**EL PASO COUNTY**

**COMMUNITY SERVICES DEPARTMENT**

October 6, 2021

**Subject: Grandview Reserve Filing No. 1 PUD Preliminary Plan – (PUDSP-21-010)**

LANDSCAPE OVERVIEW PLAN

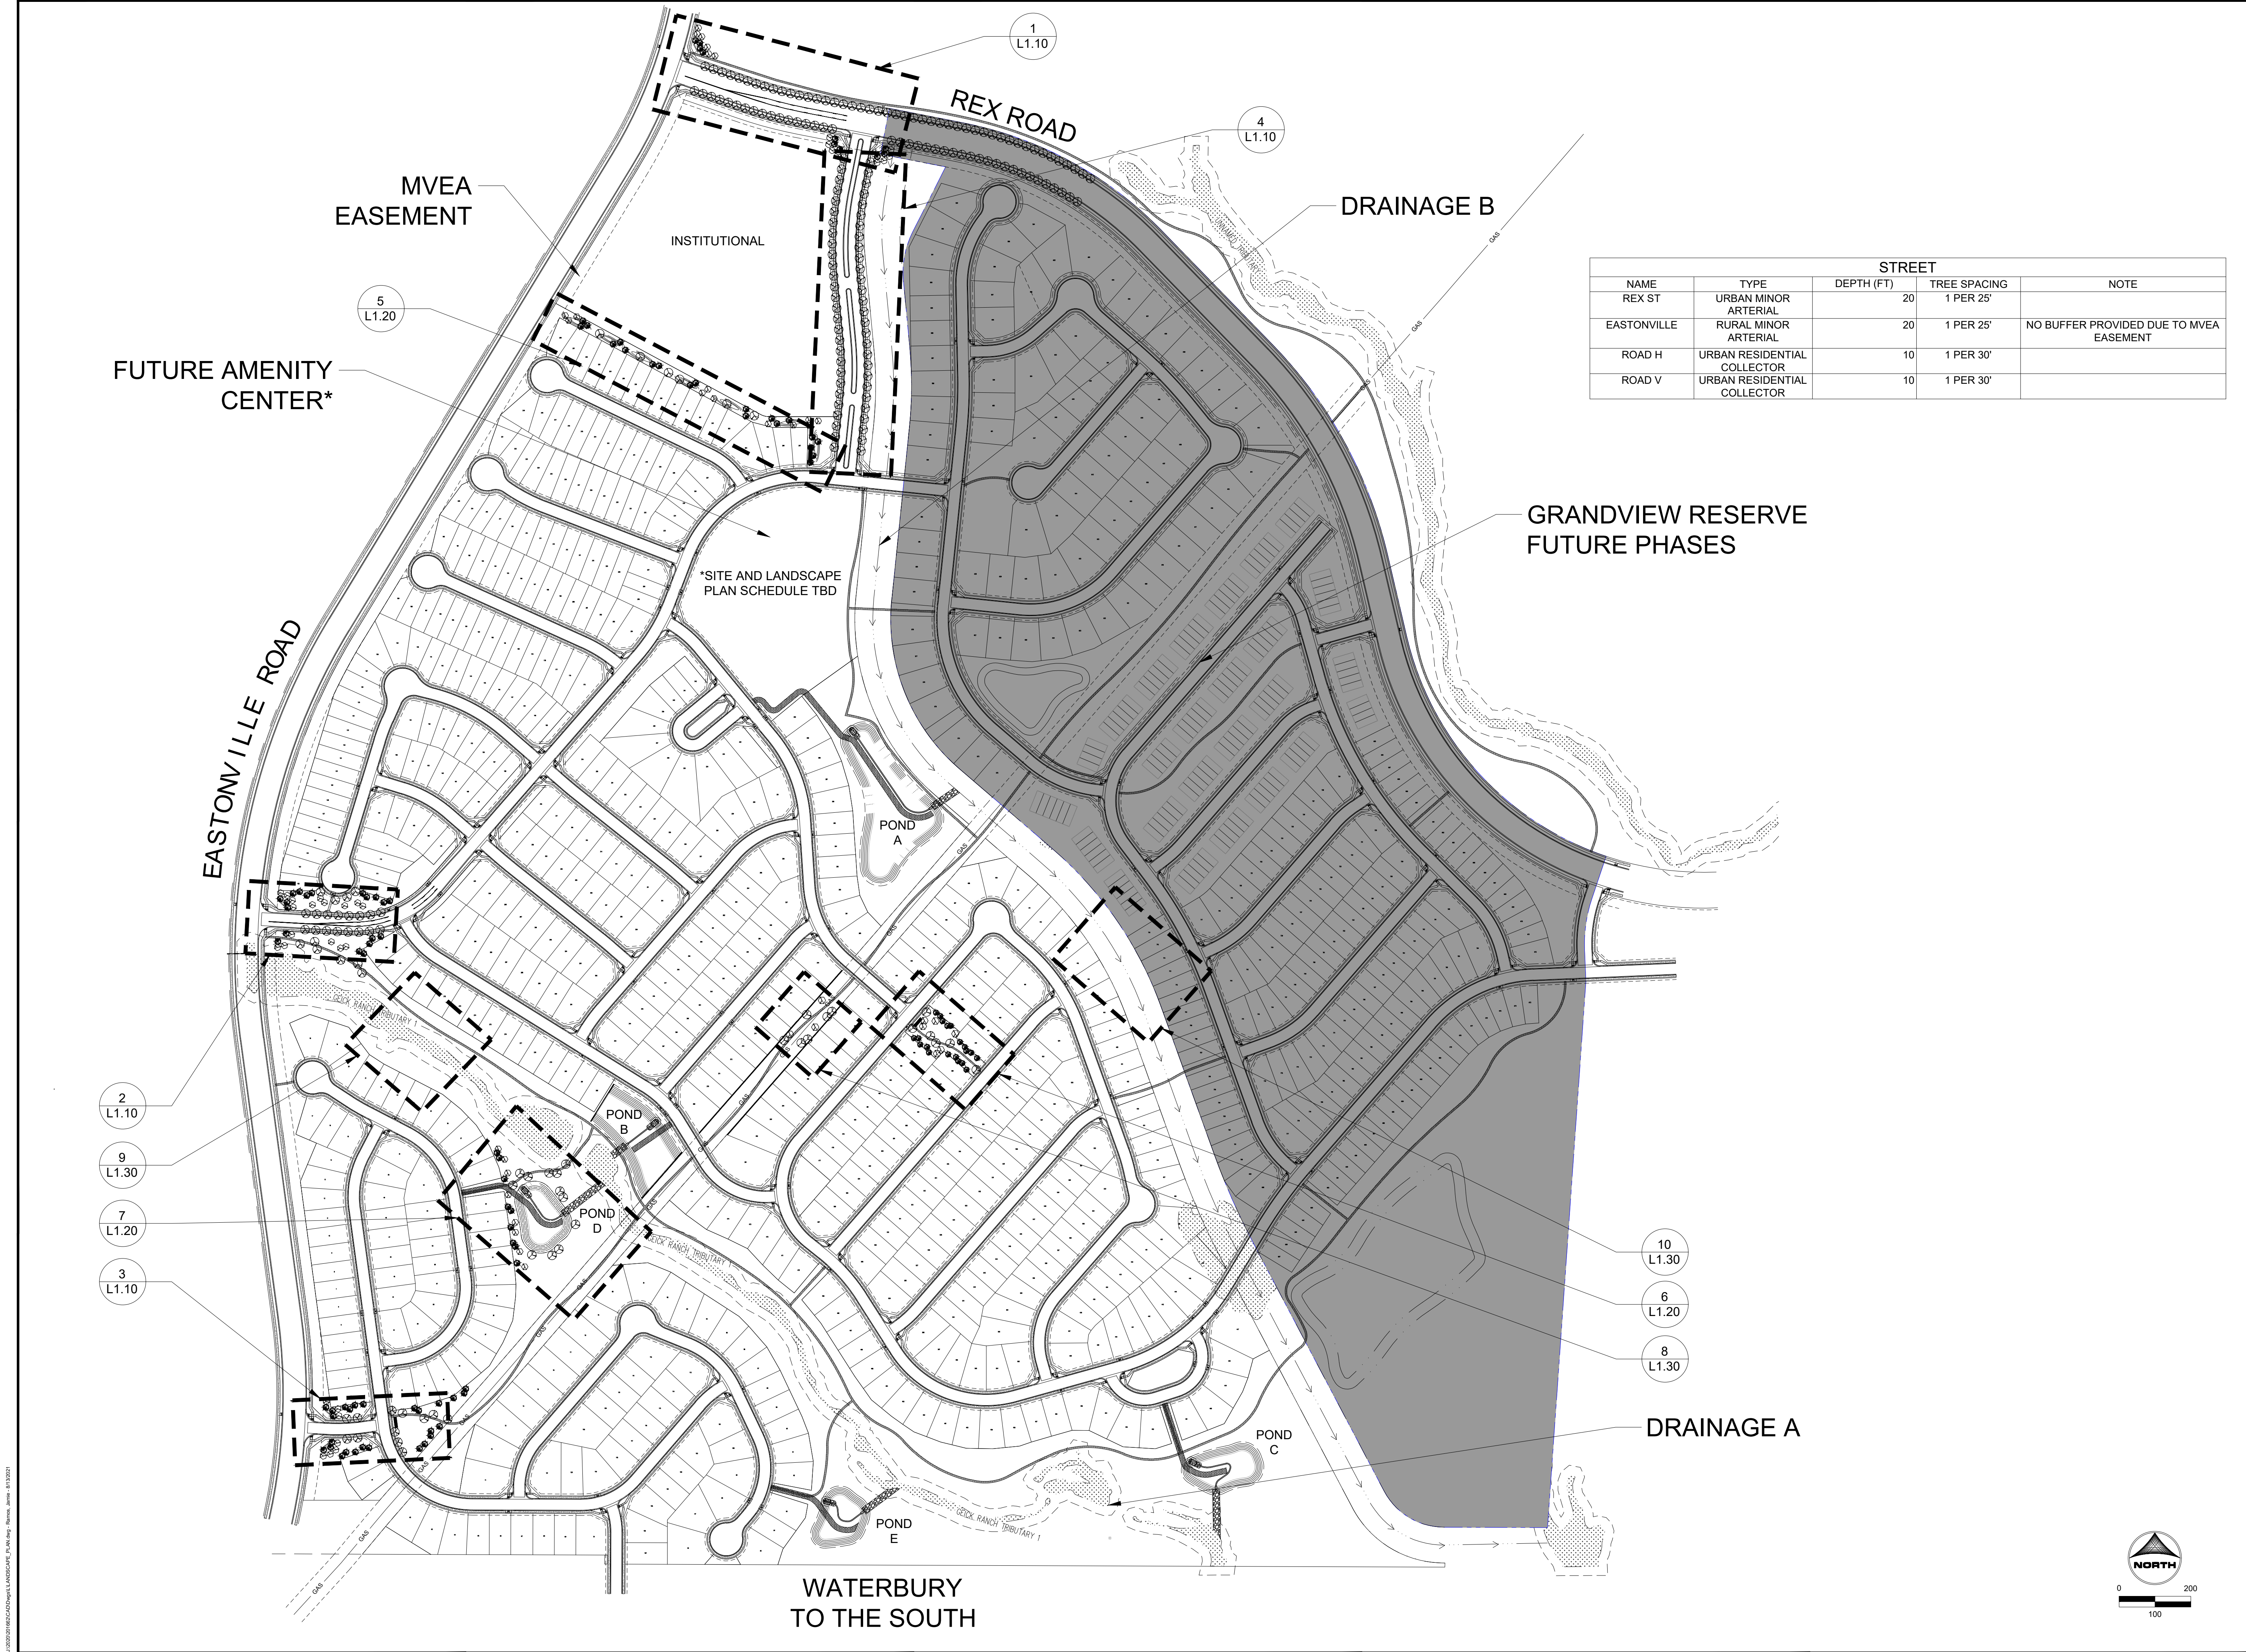
Moreover, staff recommends that the applicant submit detailed site plans for the proposed Amenity Center, as the currently proposed neighborhood pocket park does not include multi-generational recreational amenities such as a playground, multi-use turf field, or seating and picnic areas. The submitted Landscape Plans only show landscaping and a connecting pathway within the proposed pocket park.
